Ballinlee Wind Farm – Individual Submission

Case Reference: PAX91.323780

Date: 17/11/2025

Figure 3-13: Grid Connection Options Considered

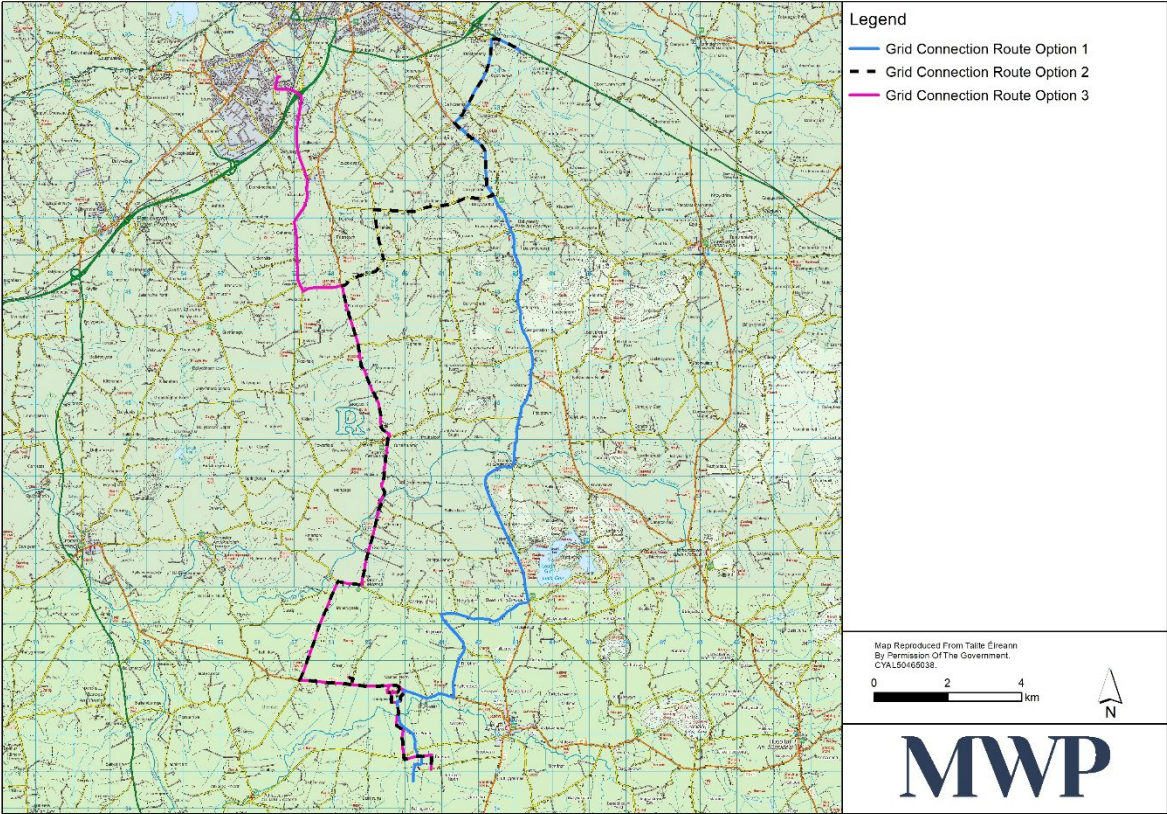
The grid connection route chosen is the longest of the options considered—27.6 km to Killonan substation—while shorter and potentially less disruptive alternatives were dismissed on vague qualitative grounds. From a systems and lifecycle perspective, this increases embodied energy, capital cost, and long-term transmission losses. An Bord Pleanála explicitly requested that grid connection alternatives be revisited, yet no quantitative comparison has been provided.
